From: Jayne Colbert [REDACTED]
Sent: 04 October 2018 11:20
To: Planning.Responses
Subject: **Warning Active Content** Planning Services Response FG/156/18/PL

WEST SUSSEX COUNTY COUNCIL CONSULTATION

TO:	Arun District Council FAO: Mrs A Gardner
FROM:	Highways, WSCC
DATE:	04/10/2018
LOCATION:	Andalucia Restaurant, 58 Ferring Street, Ferring, BN12 5JP
SUBJECT:	FG/156/18/PL Outdoor seating area on pavement consisting of 2 No. tables & 4 No. chairs to be stored when not in use.
DATE OF SITE VISIT:	
RECOMMENDATION:	☒ Advice ☐ Objection ☐ Modification ☐ No Objection ☐ More Information ☐ Refusal
S106 CONTRIBUTION TOTAL:	£N/A See below for breakdown.

PROJECT	RESTAURANTE ANDALUCIA 58-60 Ferring Street, Ferring BNT2 5JP		
TITLE			
PROPOSED CHANGE OF USE AND TABLES AND CHAIRS LICENSE			
DRAWN	DATE	SCALE	CHECKED
RM	August 2018	shown	
PROJECT	NUMBER		REVISION
BD 18114	09-01		-

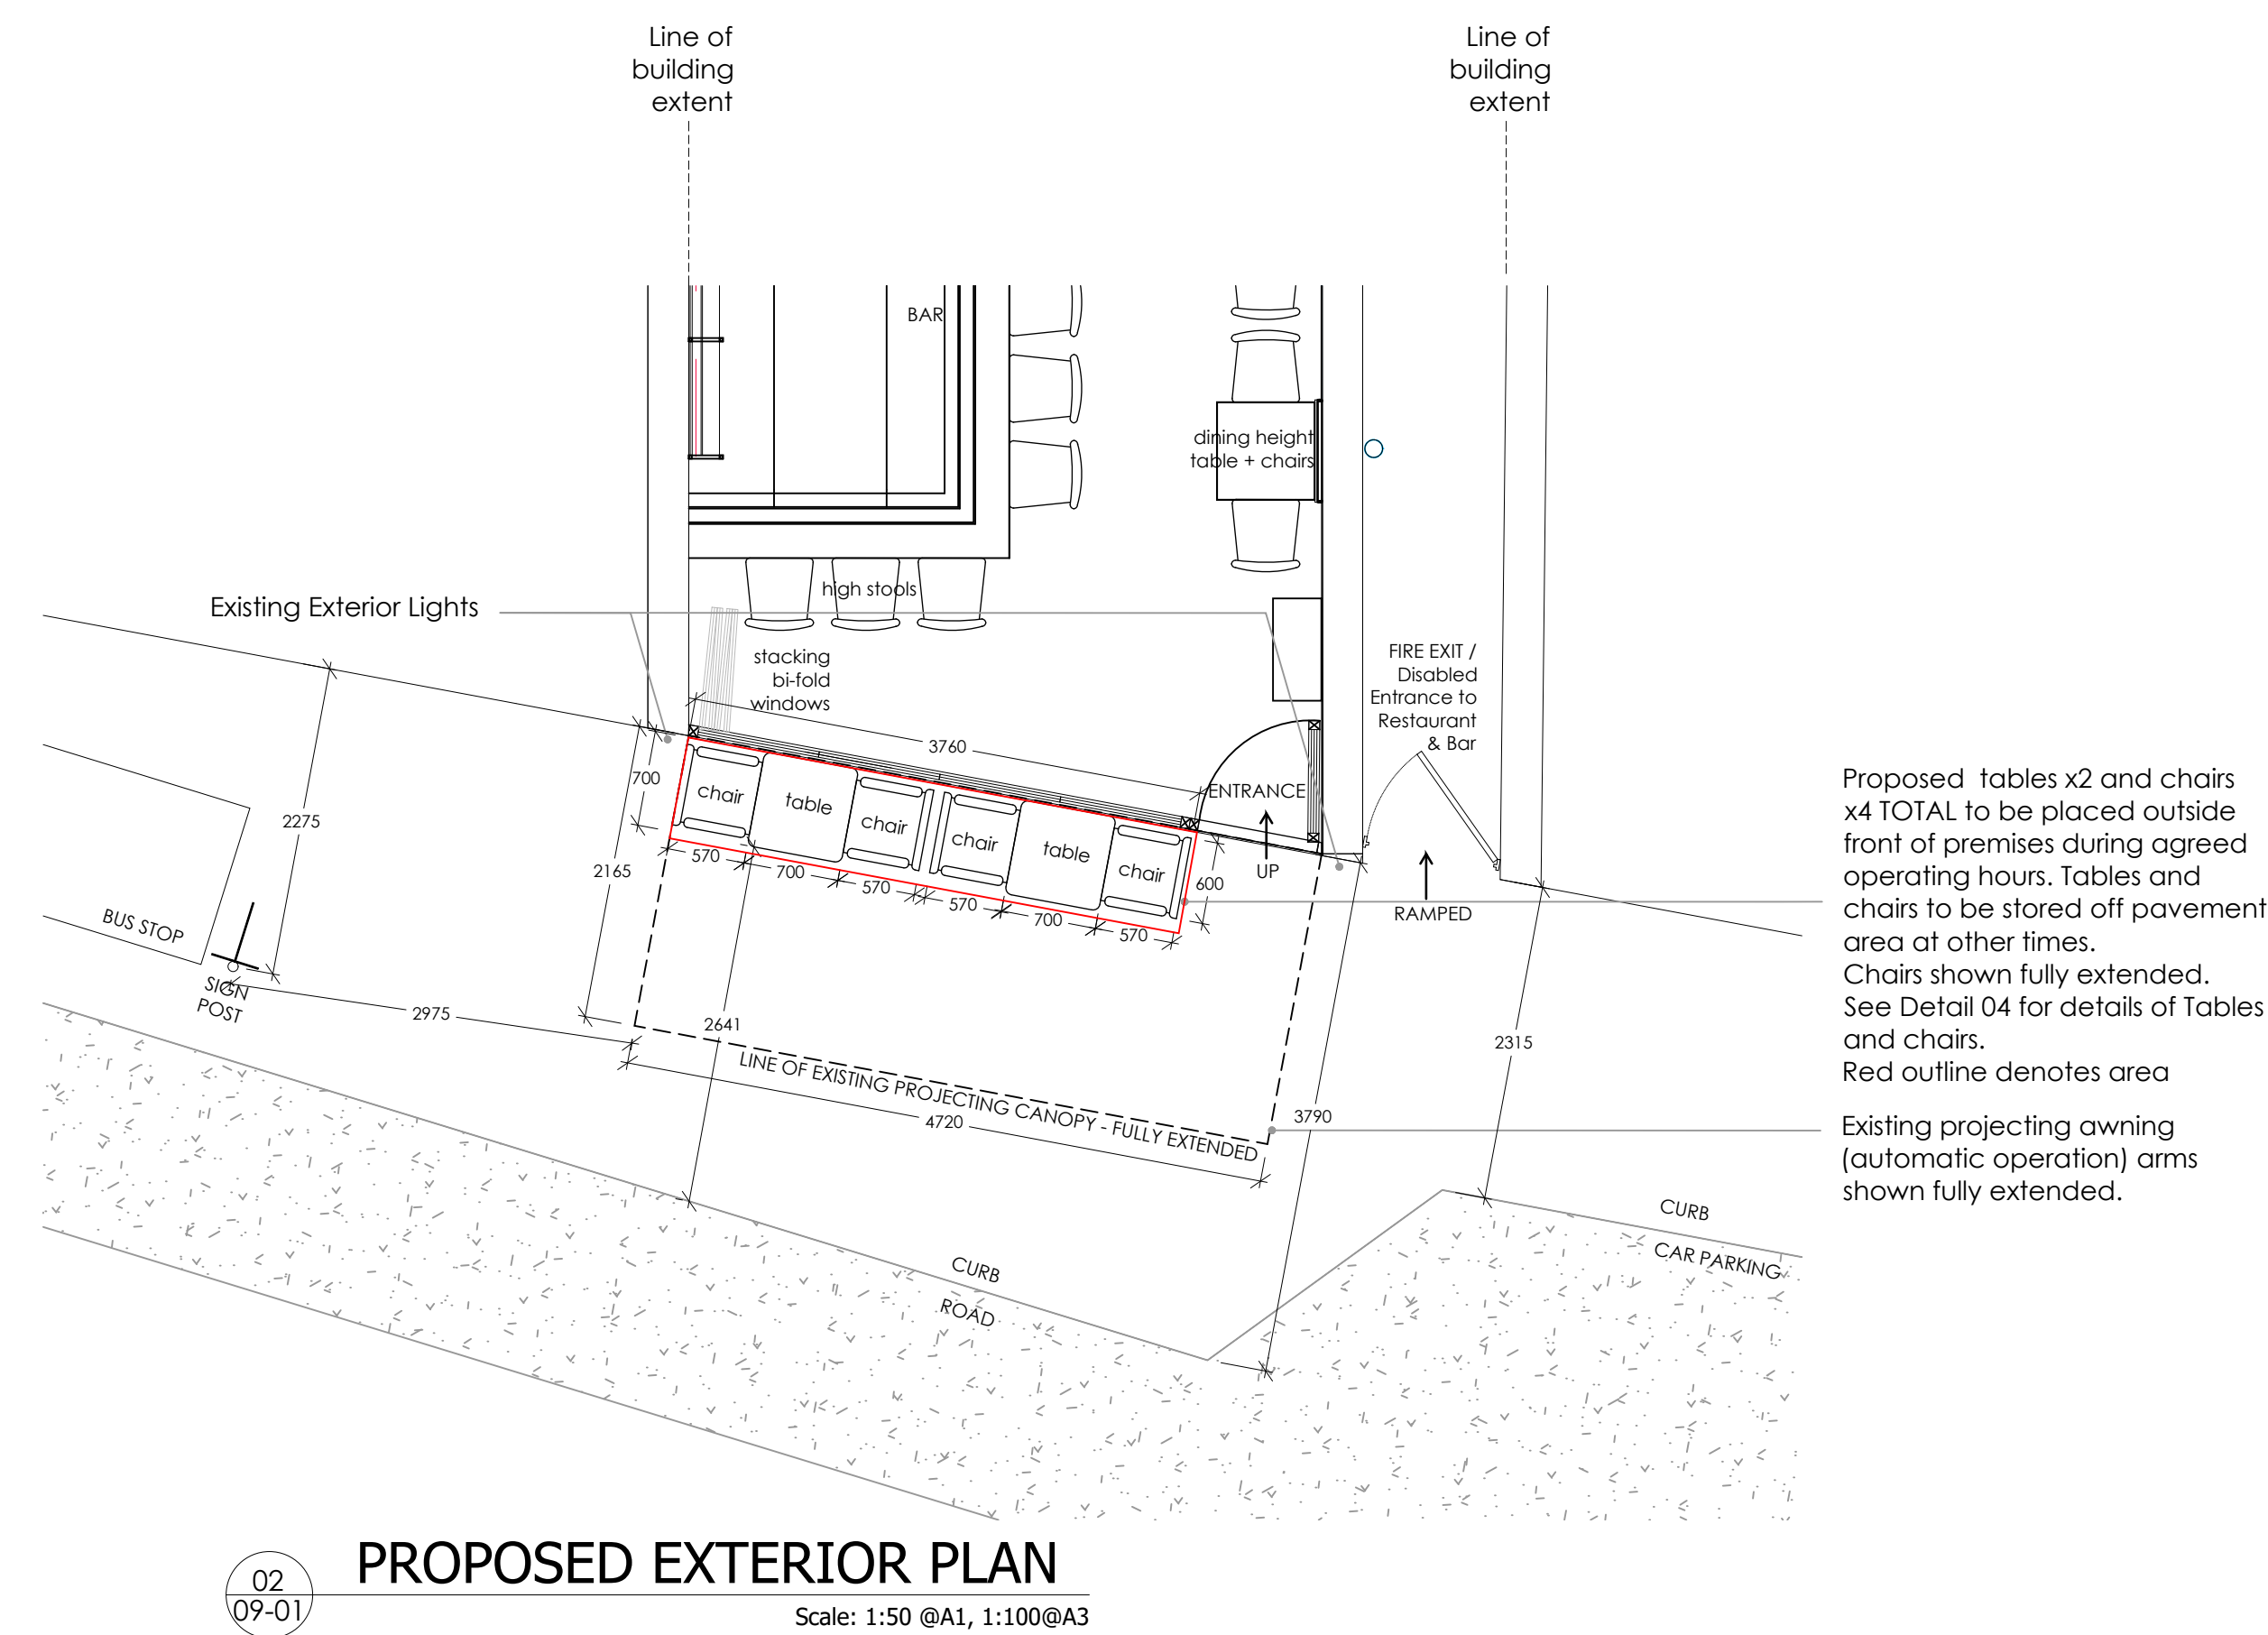
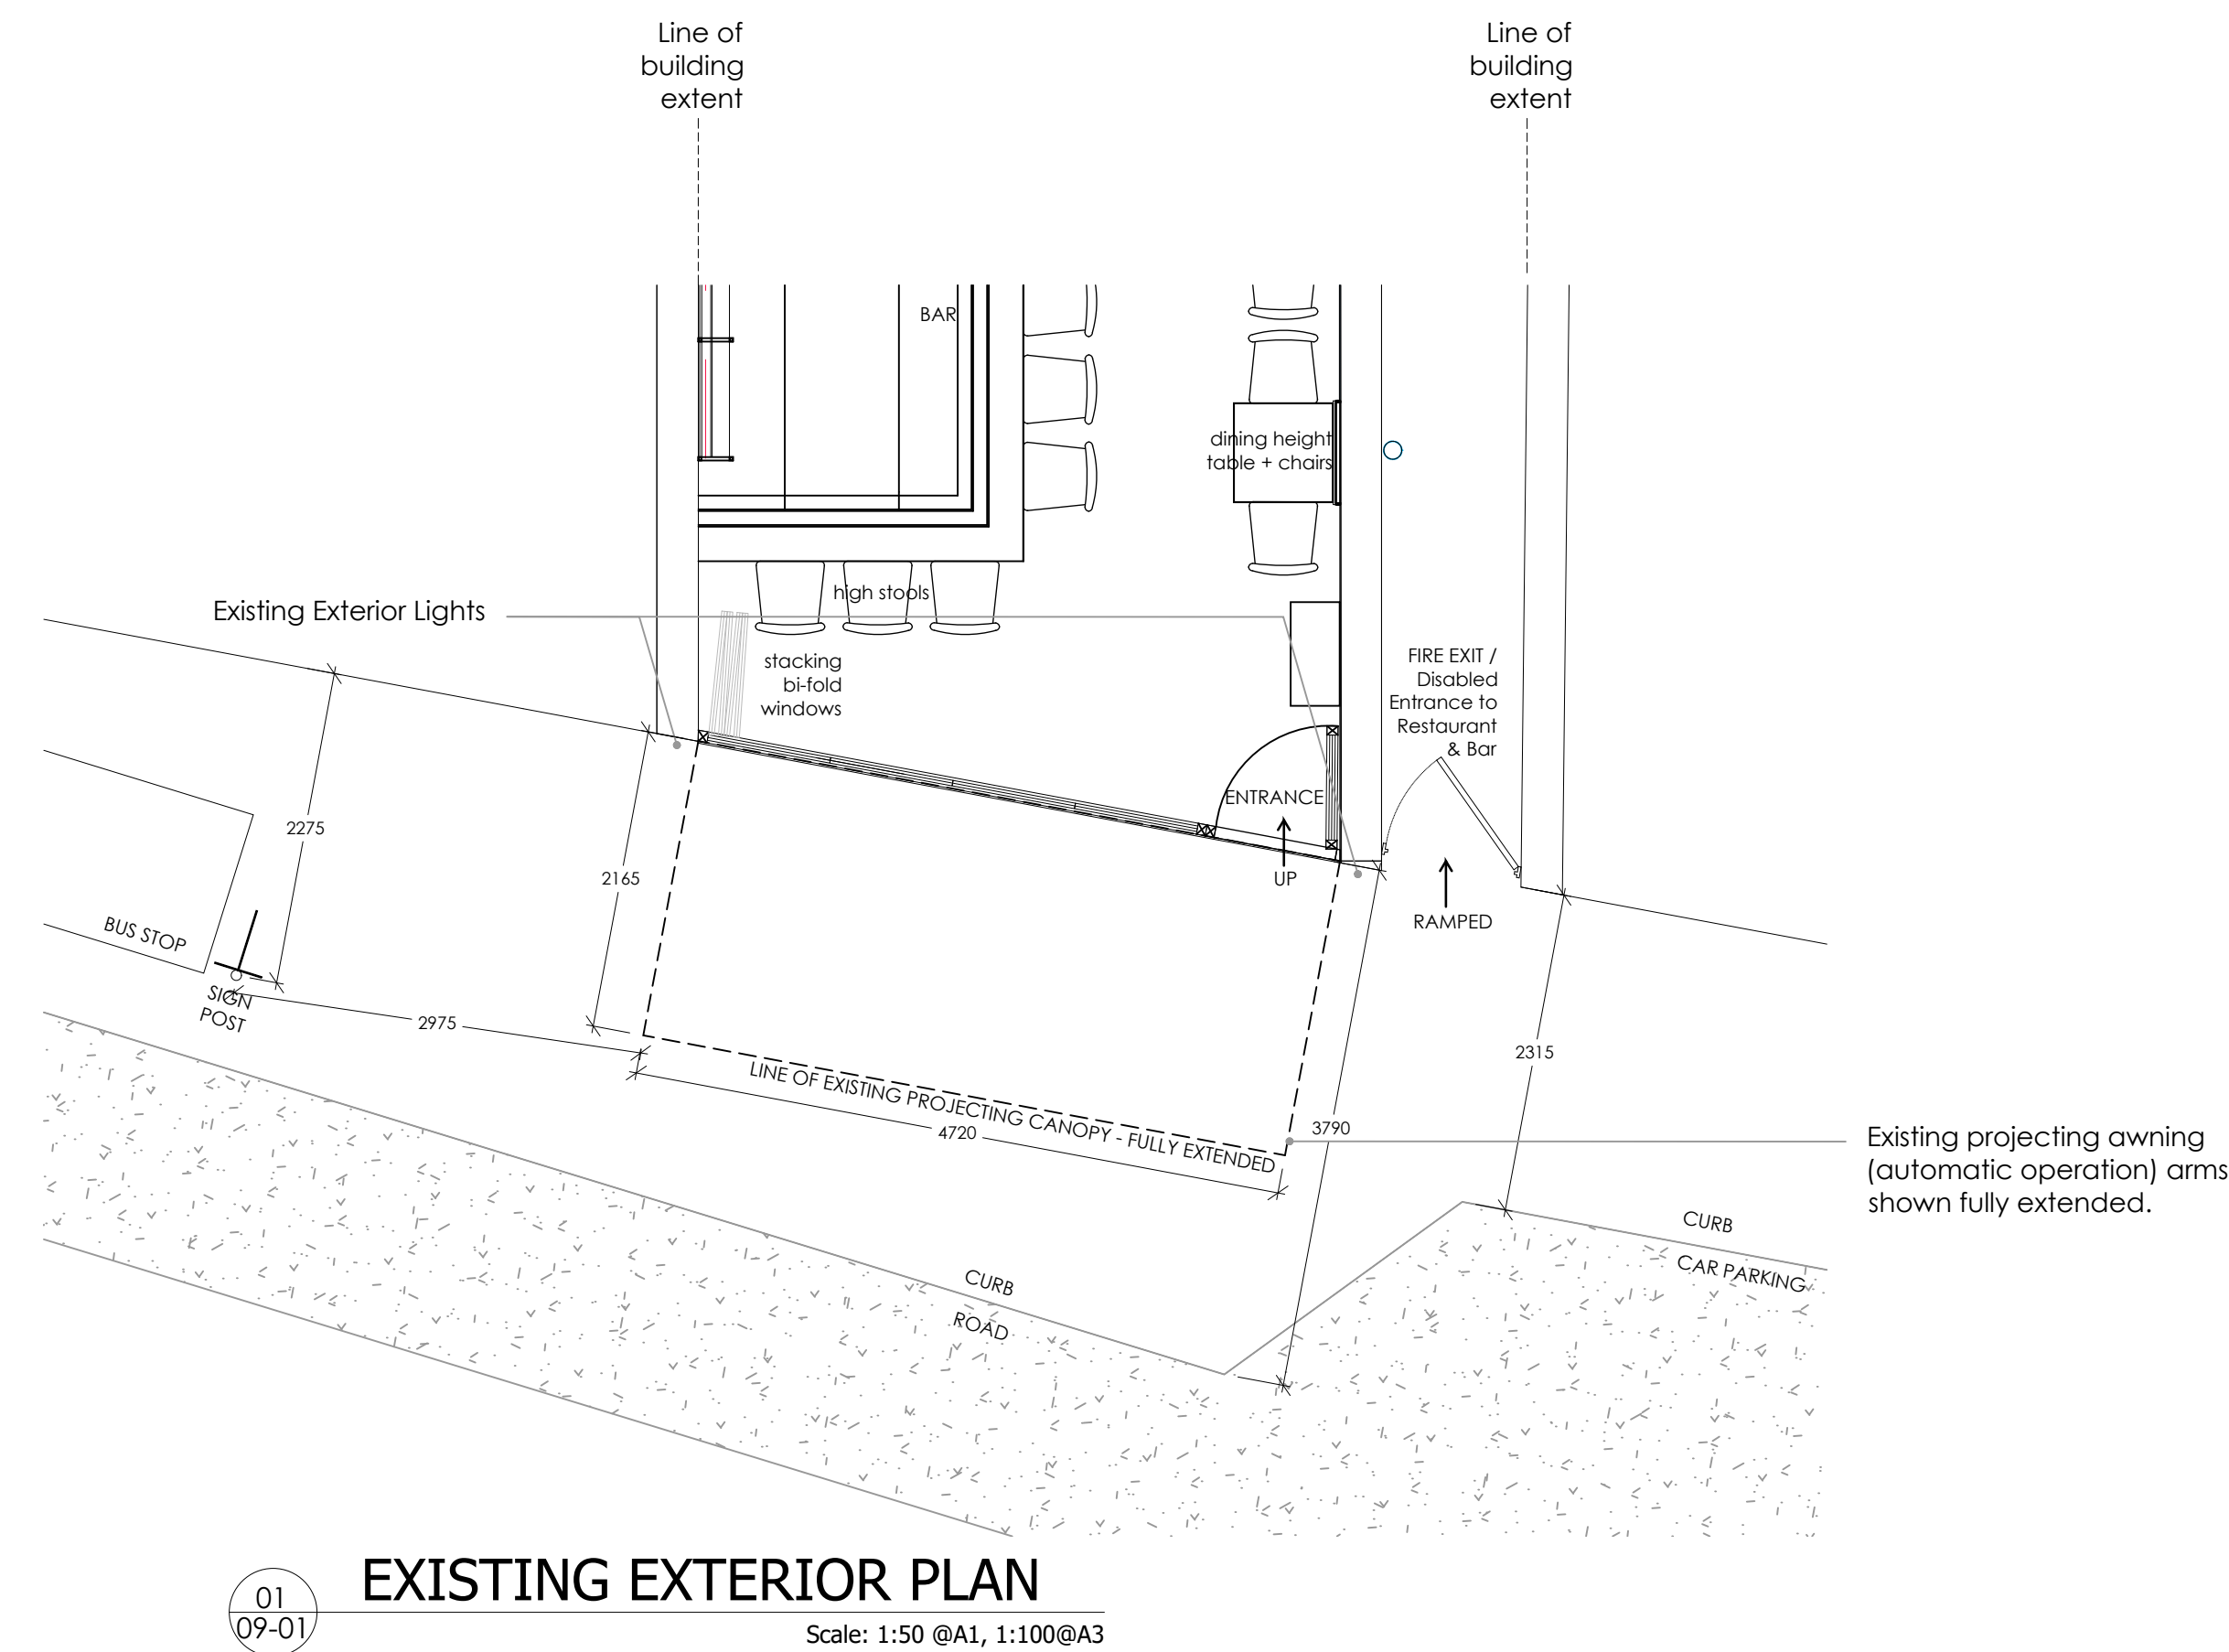
The footway along the site varies between 3.3m and 3.7m and tapers to 2.3m approximately 2.1m south of the proposed chairs and tables. There is also a bus shelter approximately 3m north of the proposed location of the tables and chairs. The bus stop layby markings run along the whole length of the site.

From the plans provided it would appear that there would be between approximately 2.5m and 2.9m available for pedestrians and bus users to use with the proposed tables and chairs. This complies with the minimum 2m width for footpaths as stated in Manual for Streets (MfS).

The items placed within the public highway are not to be permanently fixed and are to be removable. This is to permit the maintenance of the public highway and to ensure that a permanent obstruction does not result. If Planning Consent is approved, a separate Licence agreement will be required to be entered into with the Highway Authority, WSCC. It will be a requirement of the Highway Licence that tables and chairs must be removed from the highway each and every night and only placed out at times stated within the Licence agreement. The applicant is advised to contact the Highway Licensing team (01243 642105) in order to obtain the required licence.
